**Consultation Response from KC,  
 Trees**
**2021/90377 100, Lower Town End Road, Wooldale, Holmfirth, HD9 1QD**
**Erection of two storey rear extension, single storey side extension and exterior alterations**
**Date Responded: 08/03/21 | Responding Officer: Nick Goddard | Responding Ref: CA26**

Tree Protection Plan

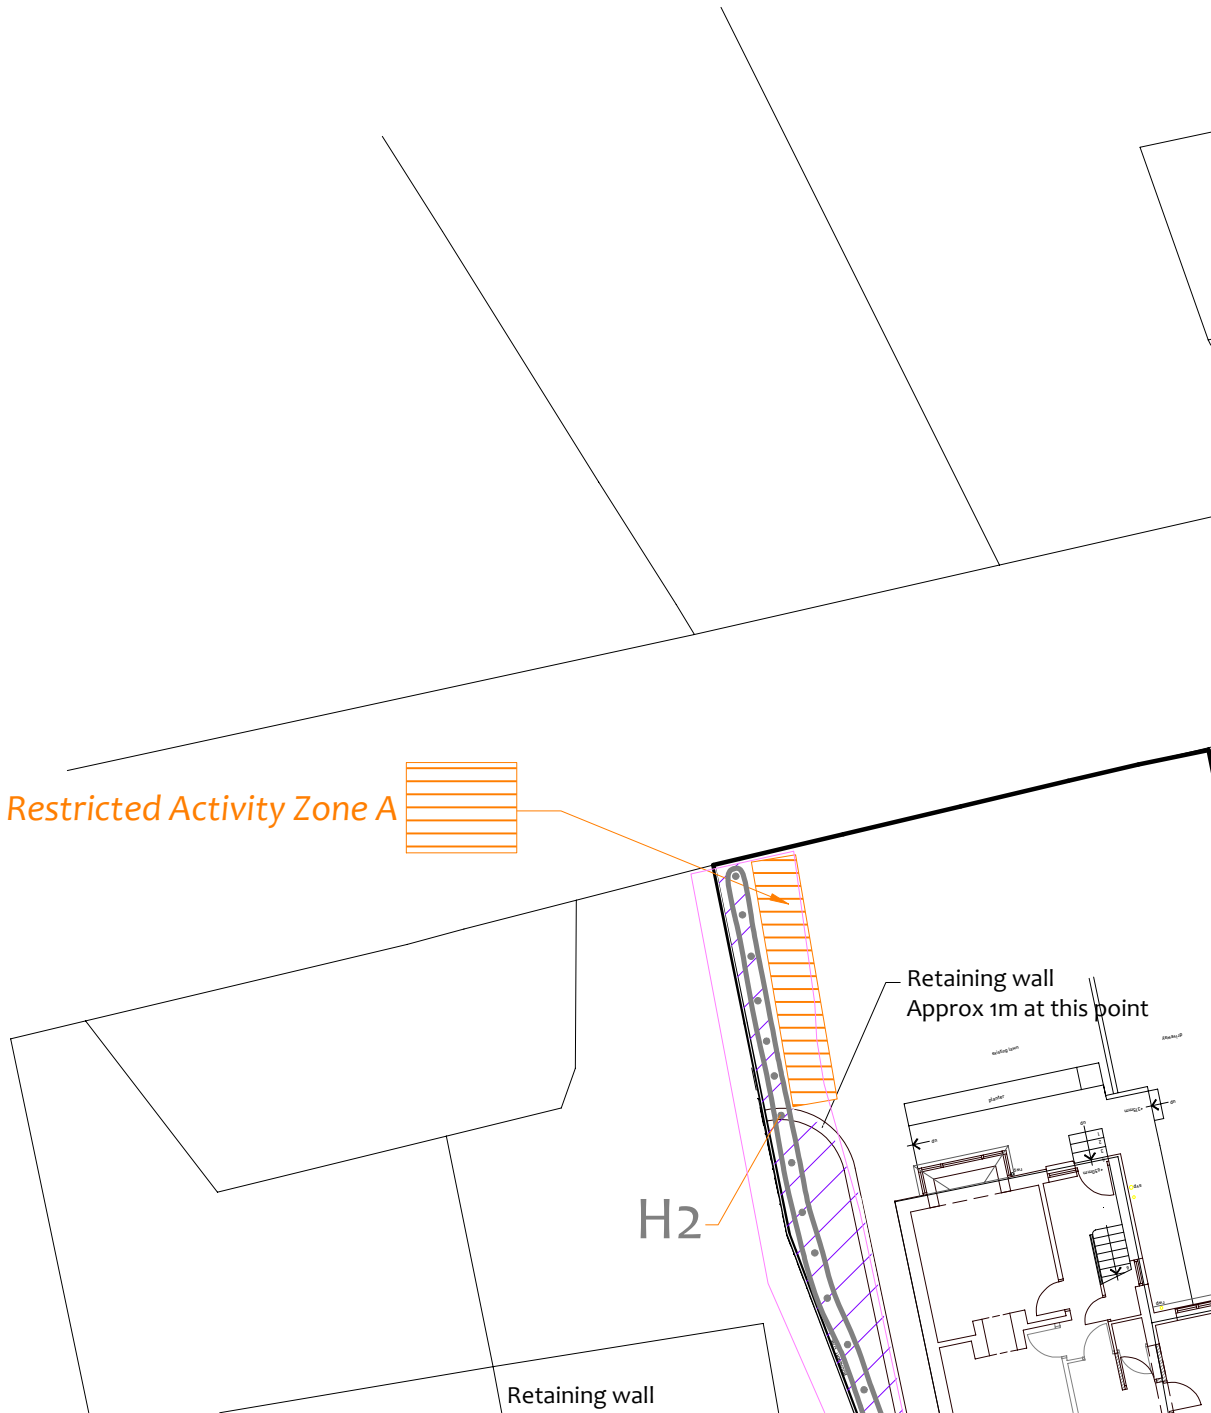
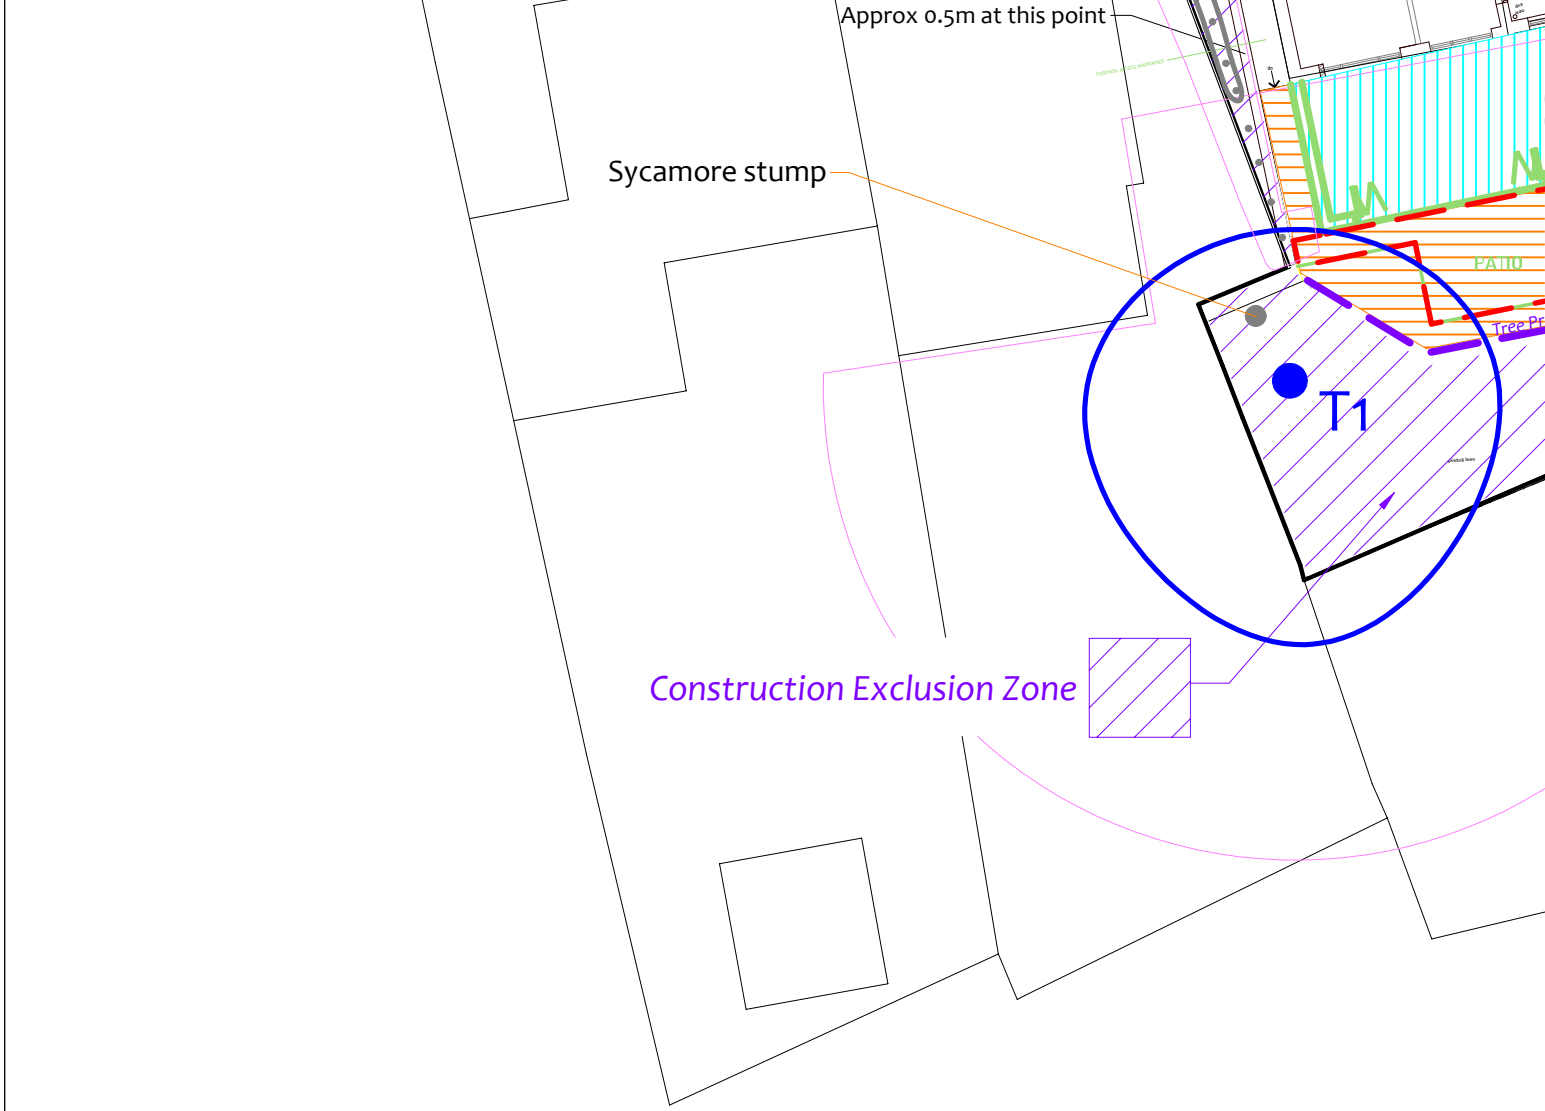
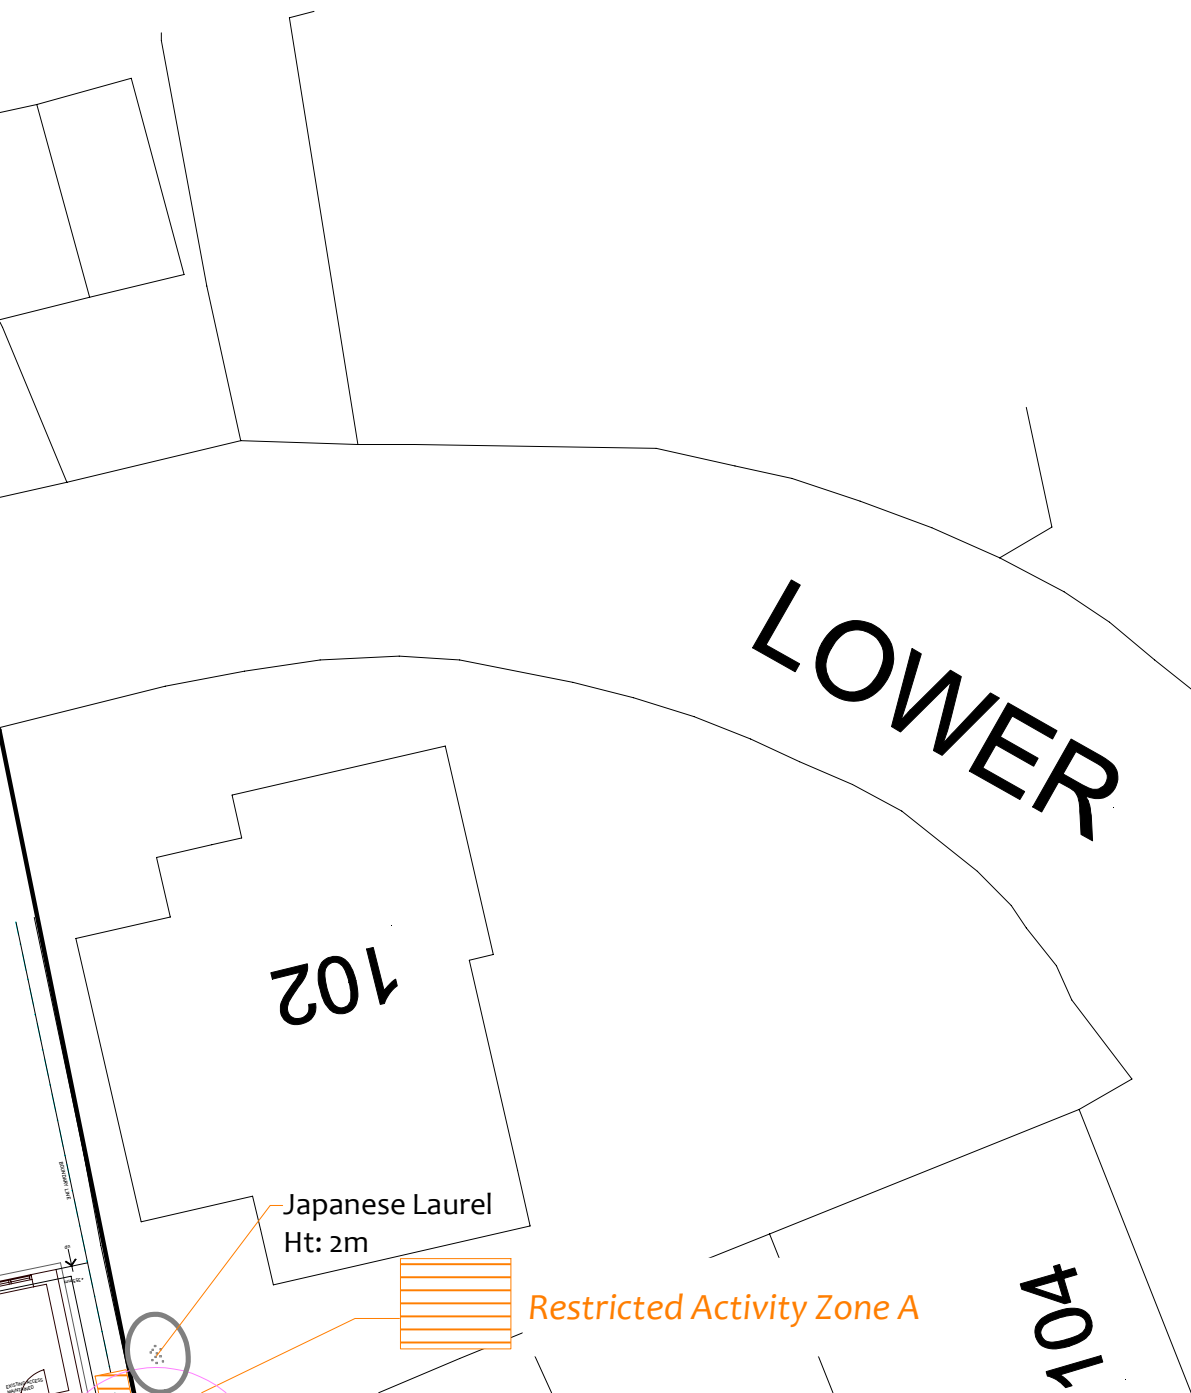
The trees on the site do not appear on any of the submitted information for this application and therefore it is not possible to fully assess the impacts they may have on the proposed extension to the rear. The proposals should have been informed and supported by a tree survey showing the extent of canopy spread, and root protection area of the trees. An impact assessment could then be made as to which trees are required to be removed and what measures are needed to retain the good quality tree on site.

At present I could not support the proposals as they do not appear to meet the requirements of LP24i and LP33 however I would be happy to look at the proposals again if a tree survey and method statement are submitted to demonstrate how the proposals will be constructed so close to the tree without causing direct or long term harm.
